**REQUEST**

Current Zoning: OFC (office flex campus)  
 Proposed Zoning: IMU(CD) (innovation mixed use, conditional)

Approximately 19.81 acres located on the south side of Alexandriana Road, east side of Statesville Road, and west of Twin Lakes Parkway, north of Interstate 485.

**SUMMARY OF PETITION**

TECHNICAL DATA SHEET

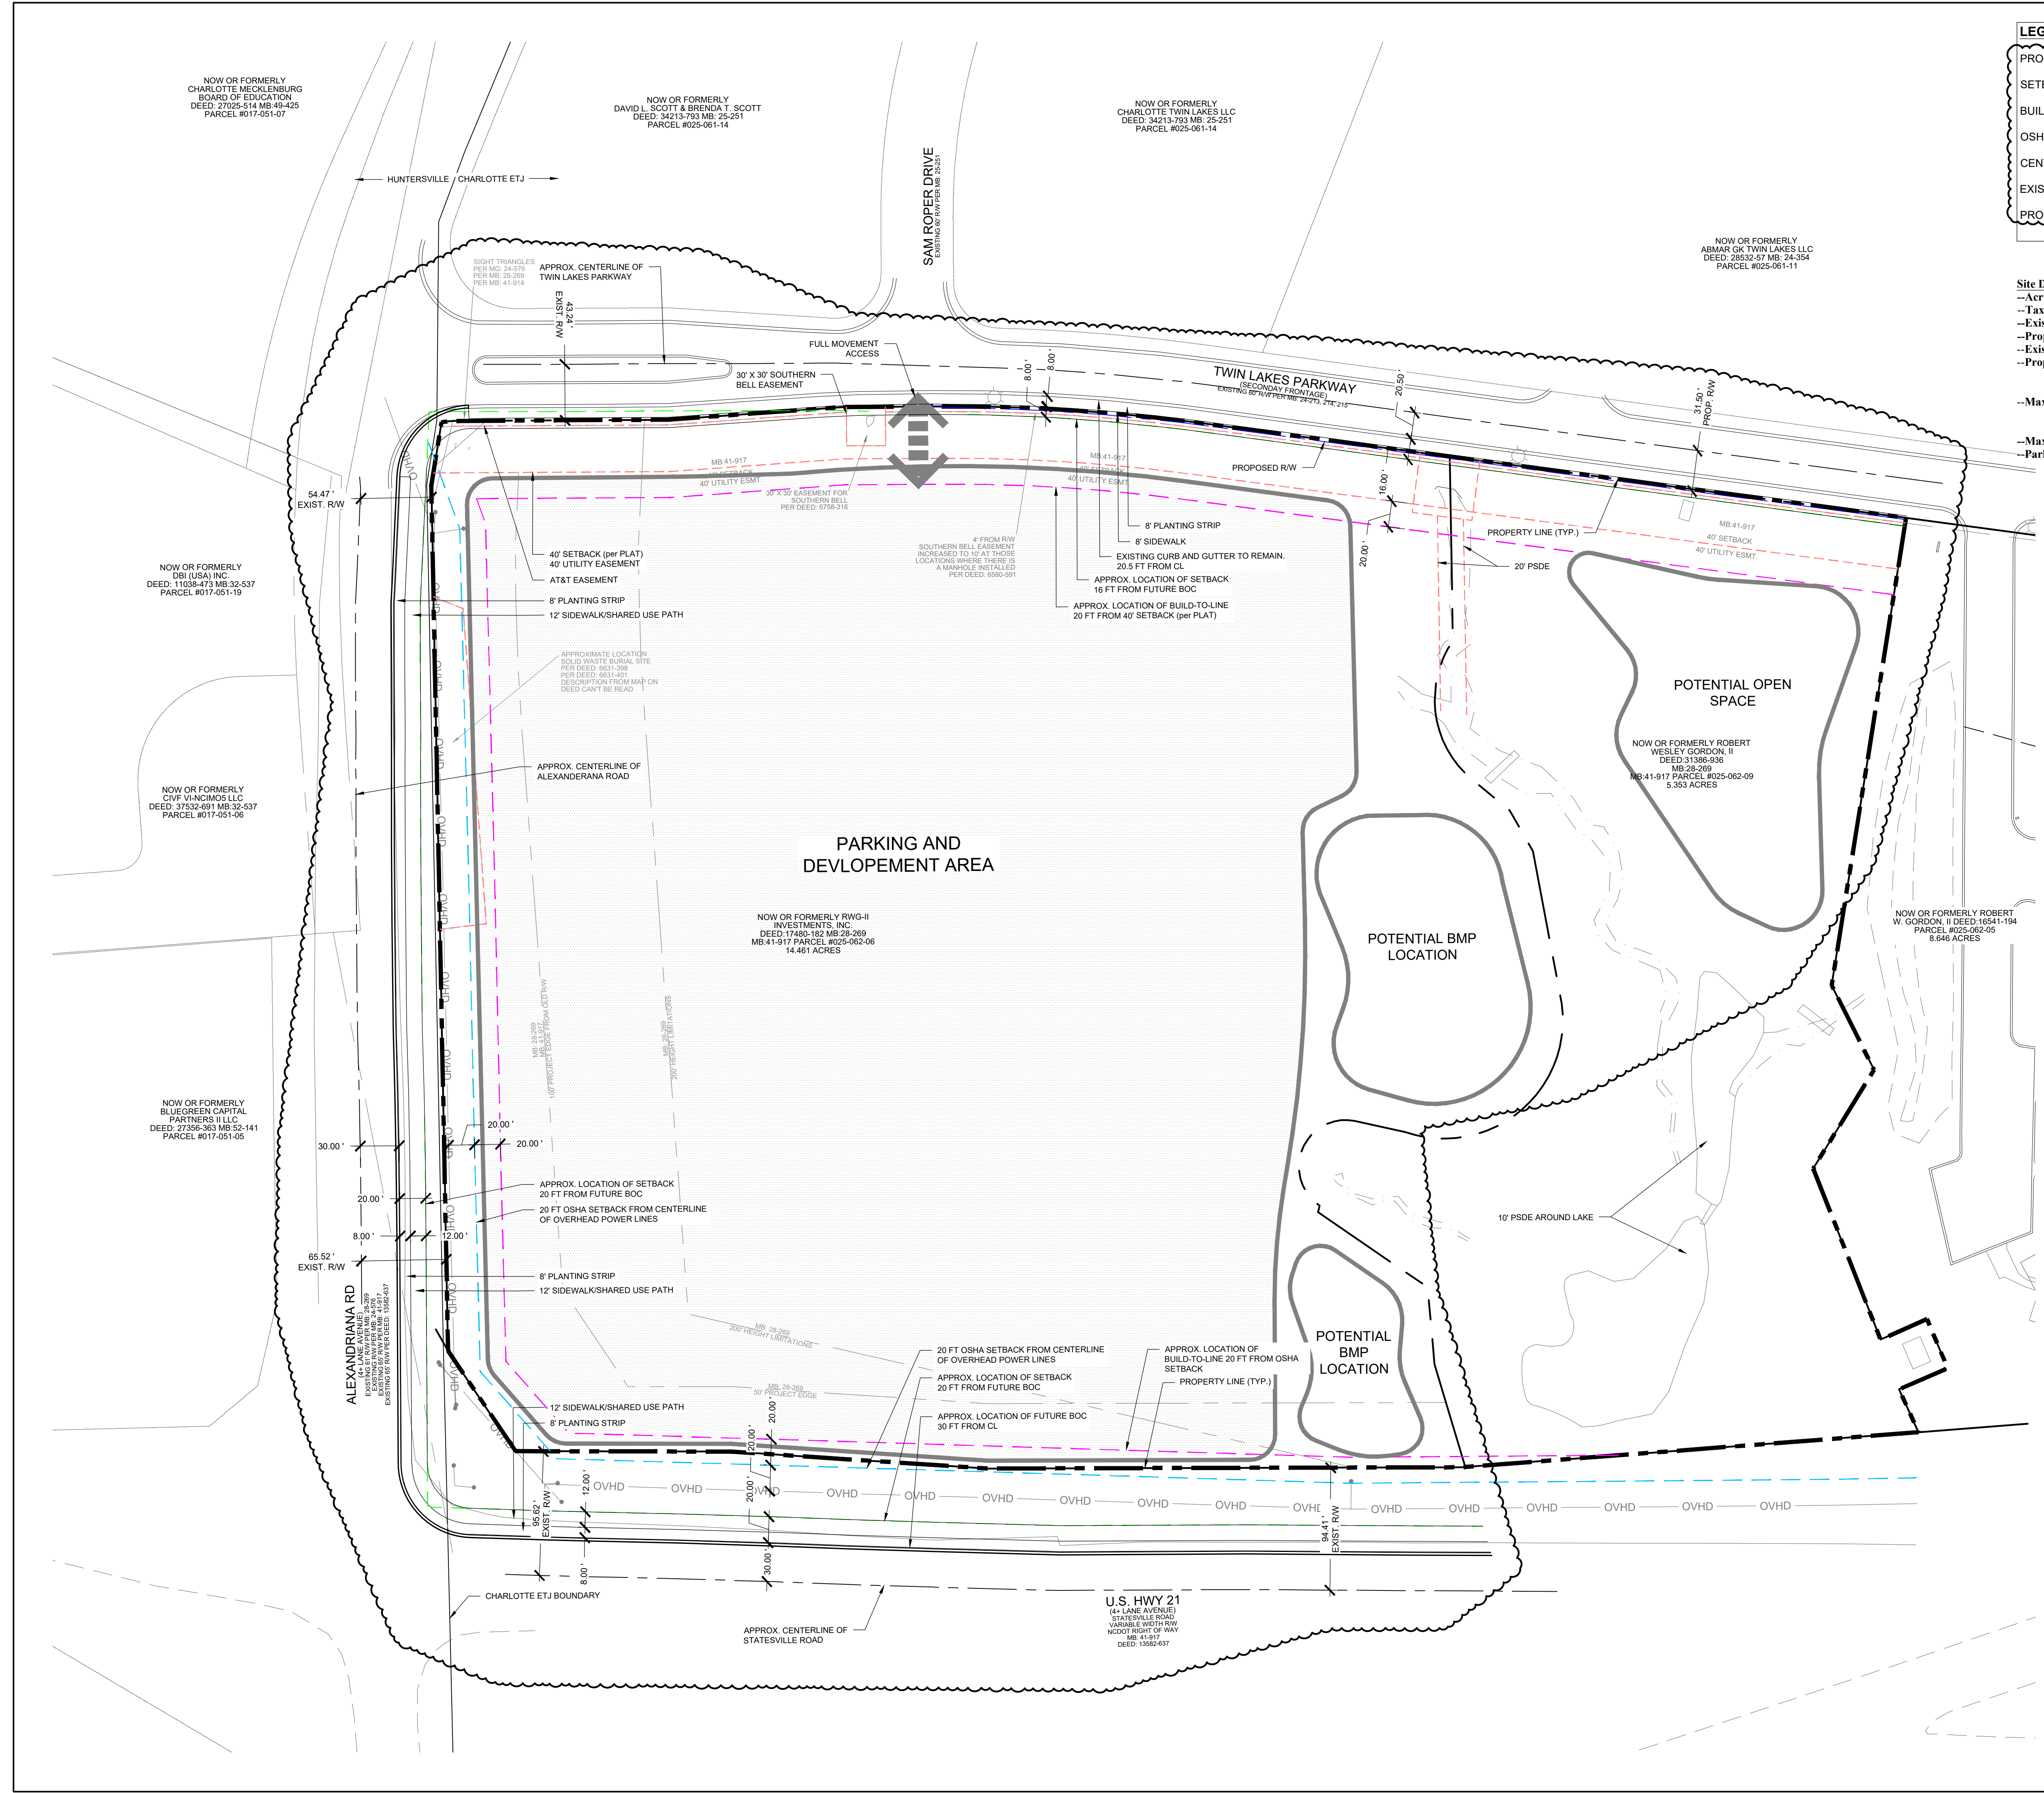
1. Site plan shows dimensions but still needs to label the centerline to curb dimension along Alexandriana Rd as "Centerline to future curb location". **Addressed**
